REQUEST

Current Zoning: MX-2 (mixed use district-2)
Proposed Zoning: N2-A(CD) (neighborhood 2-A, conditional)

The petition proposes a residential community of up to ~~71~~ **70** multi-family attached dwelling units.

Staff does not recommend approval of this petition in its current form.

# RZ-1.0

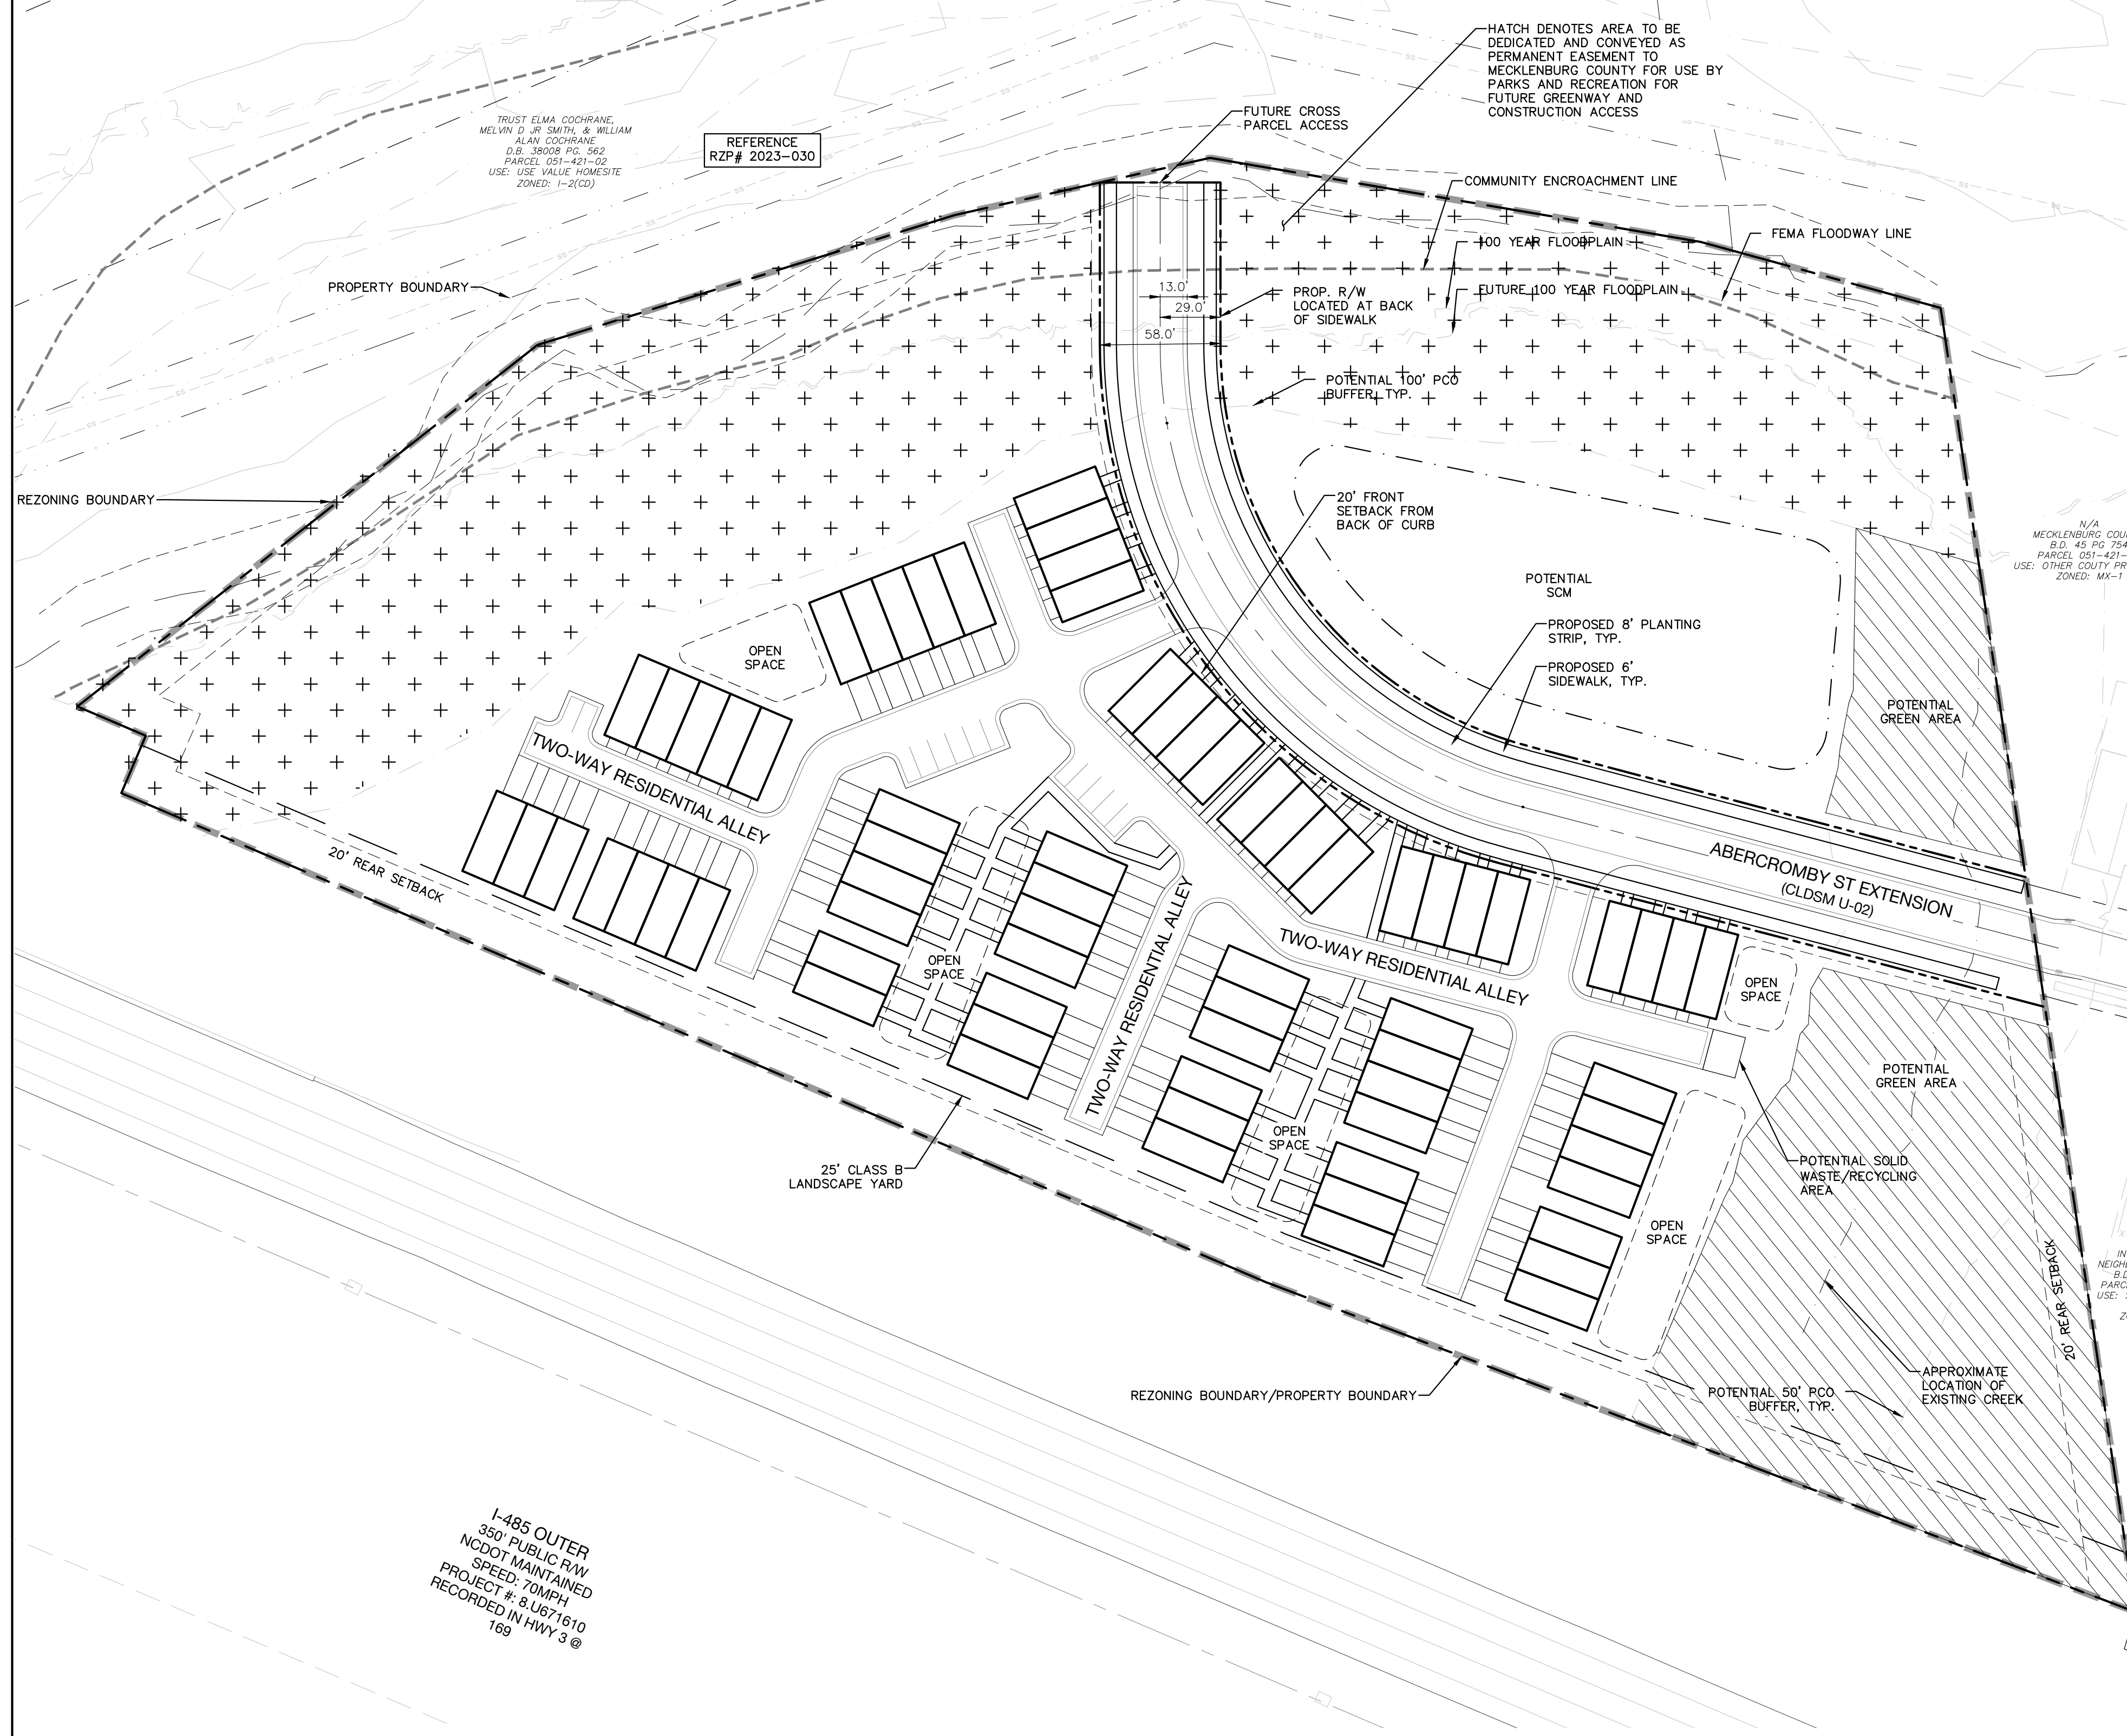
1. ~~Roadway cross-section is called out as USDG U-02. Please revise all reference to roadway standard cross-section to be CLDSM U-02.~~ Addressed

3. ~~MCPR requests clarification of the hatched area on the current site plan. The Greenway Easement area to be dedicated and conveyed to Mecklenburg County must extend to and connect to both sides of the public ROW.~~ Addressed
4. Green area must be comprised of existing tree canopy.
